# **01** LETTER OF SUMMARY OF RESPONSES TO COMMENTS

**Re: Summary of Responses to Administrative Amendment Application Comments  
Bernalillo County Regional Outdoor Sports Complex located at 5601 University Blvd SE  
Project #SI-2019-00315**

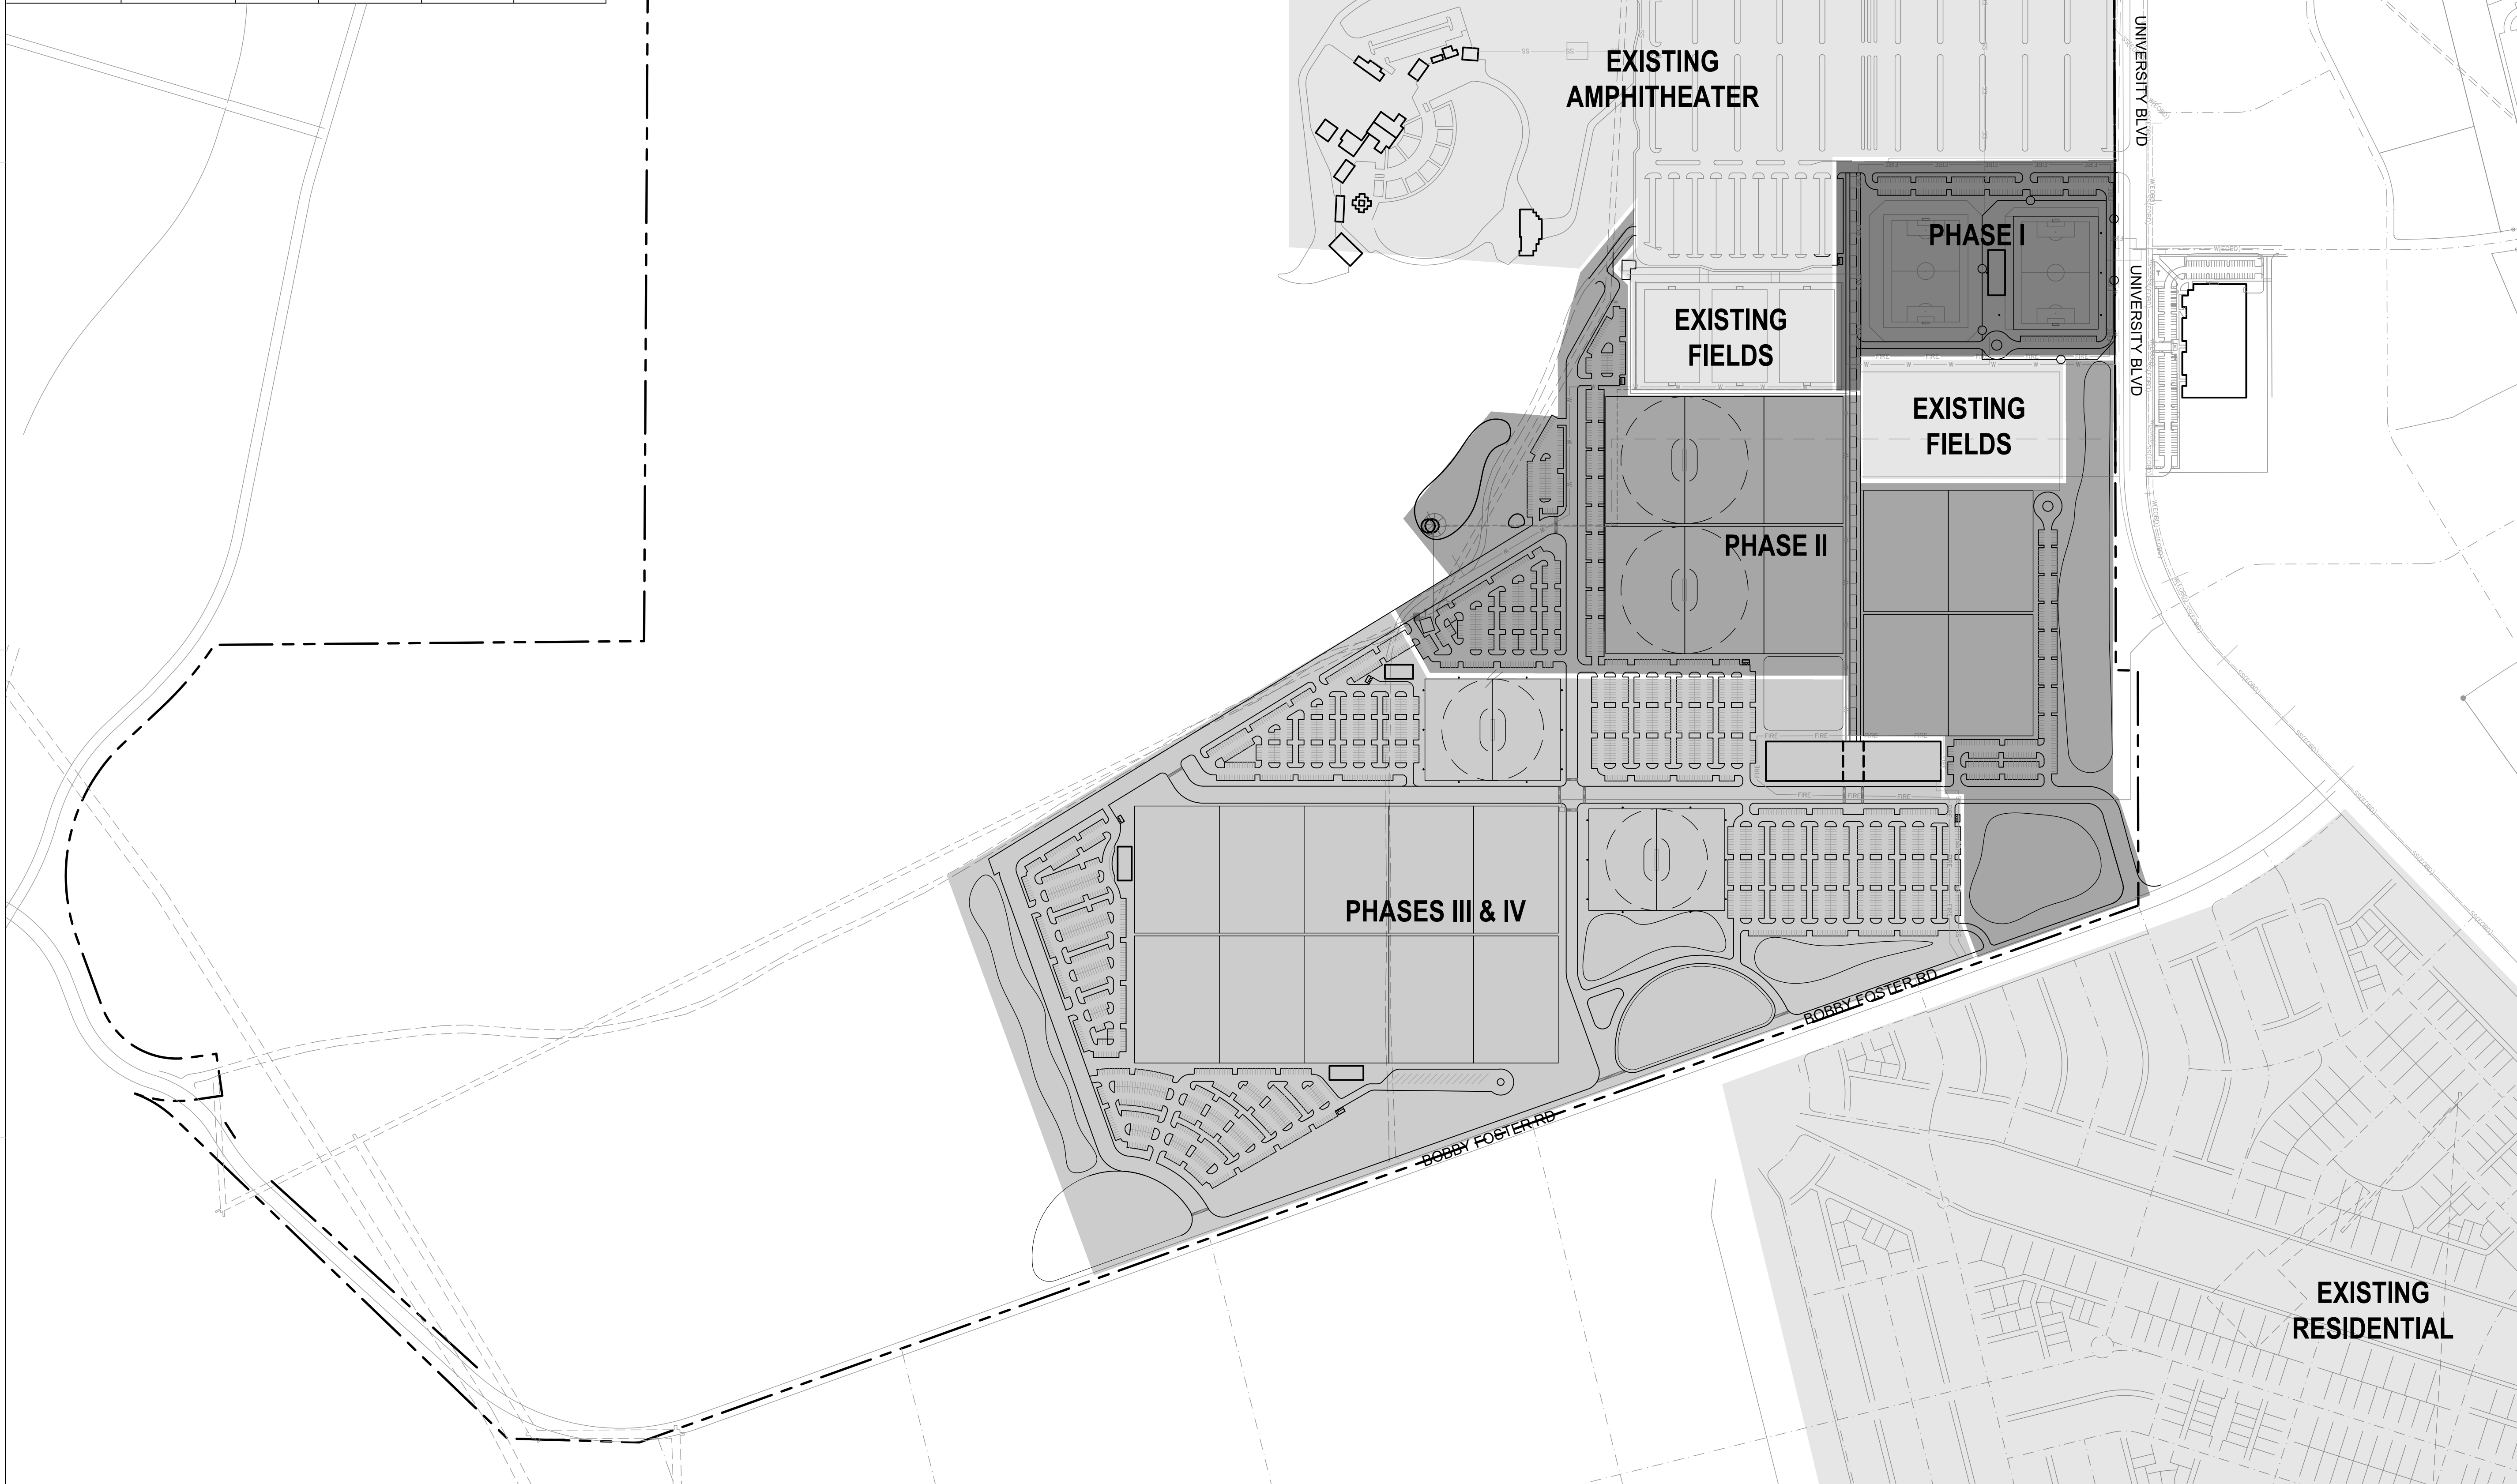
**Comment 9: Calculate handicapped space requirements. Identify all handicapped parking spaces, provide dimensioning, required van accessible aisles and handicapped space signage along with the "No Parking" pavement marking for the van accessible aisles.**

**Comment 10: Provide required motorcycle parking and motorcycle parking signage as well as bicycle parking per the IDO requirements.**

Handicapped parking spaces have been identified and calculations of the required spaces have been added to the parking calculations on sheet AS102 and detail C4 on sheet AS401 indicates typical dimensioning and markings/signage.

Motorcycle and bicycle parking calculations have been added to the parking calculations on sheet AS102 and are indicated on sheet AS402 in details C4 and B4...

B1 SITE PLAN ENLARGEMENT - PHASE I
1" = 50'-0"
0 50' 100'

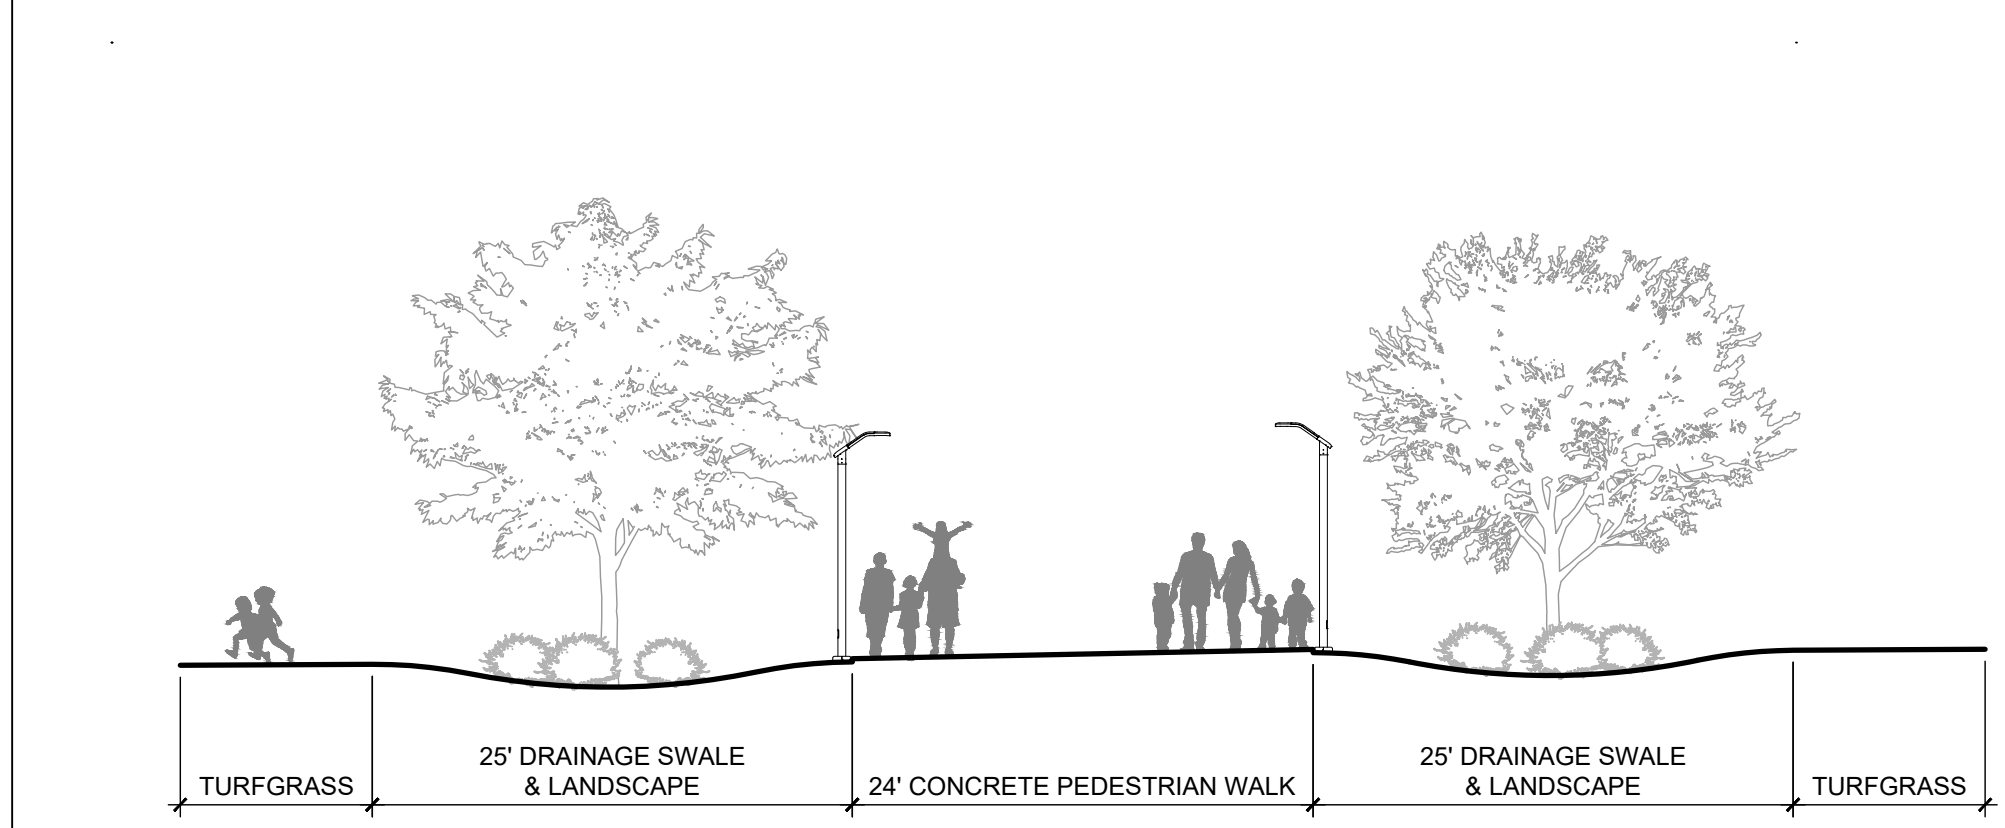
**Comment 8: For Phase I on the drop off area, ensure sufficient turning radii for the vehicles. Call out dimensions pertaining to the drop-off area.**

Drop-off areas have sufficient turning radii and their dimensions have been indicated on sheet AS101.

B4 TYPICAL PARKING ISLAND, STALL, AND DRIVE
NTS

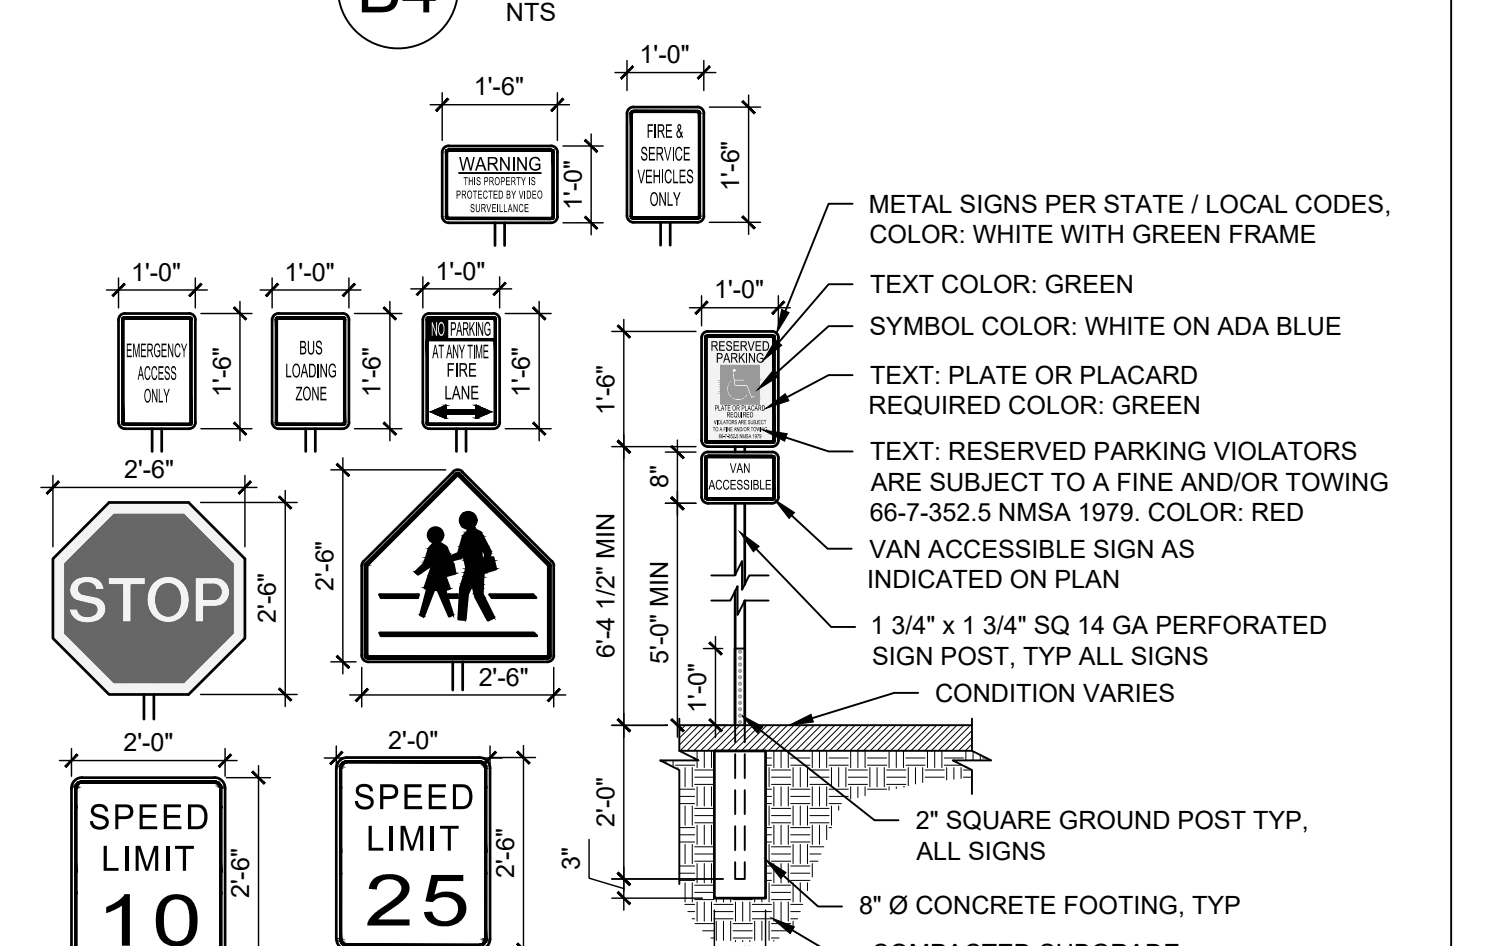
***Comment 3: Show dimensioning for all parking spaces, aisles, new drives, pedestrian paths, parking islands as well as curb radii.***

Typical details that indicate the requested information for elements such as parking spaces, aisles, new drives, pedestrian paths, and parking islands have been provided on sheets AS401 and AS402.

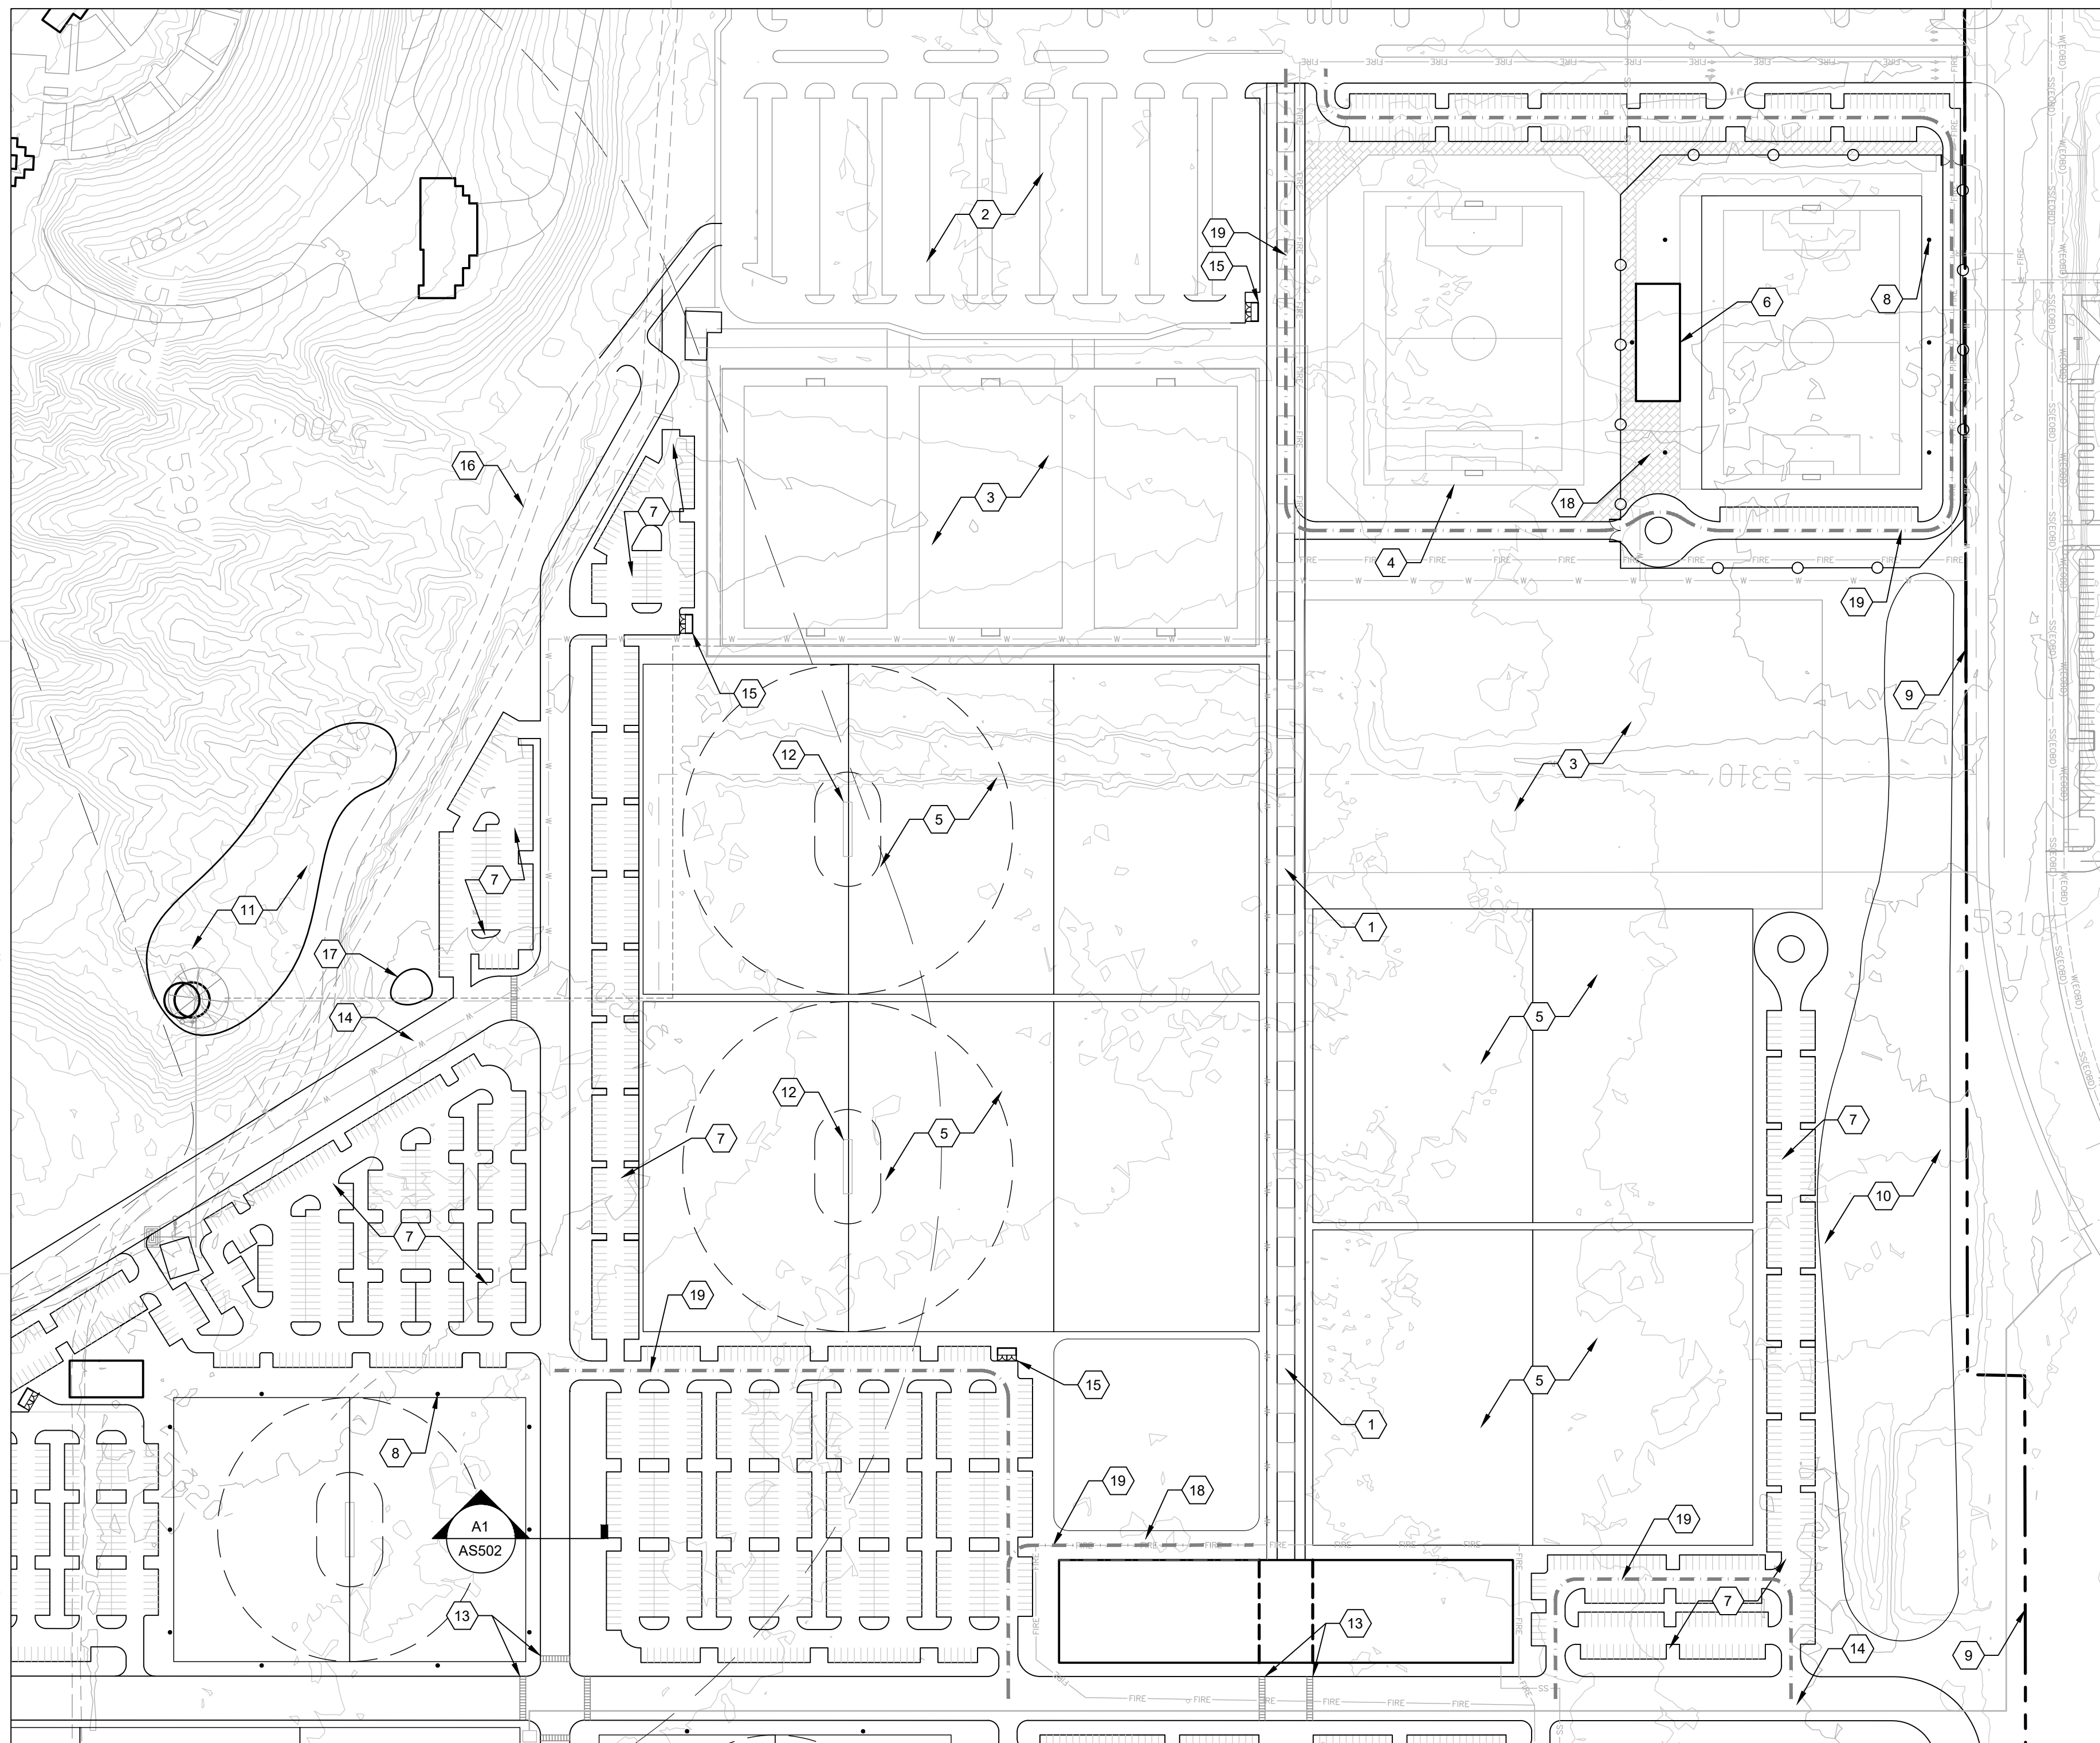
***Comment 2: Solid Waste and Fire Marshall approval are required.***

**Comment 7: For Phase I Site Plan, follow DPM requirements with regard to spacing of accessway to parking lot from University Blvd.**

Dumpster locations are shown on sheets AS401 and AS402 and Fire Lanes are shown on sheet AS402.

The accessway to the parking lot from University Blvd has been shifted to the west, as indicated in sheet AS402, in order to comply with the DPM spacing requirements.
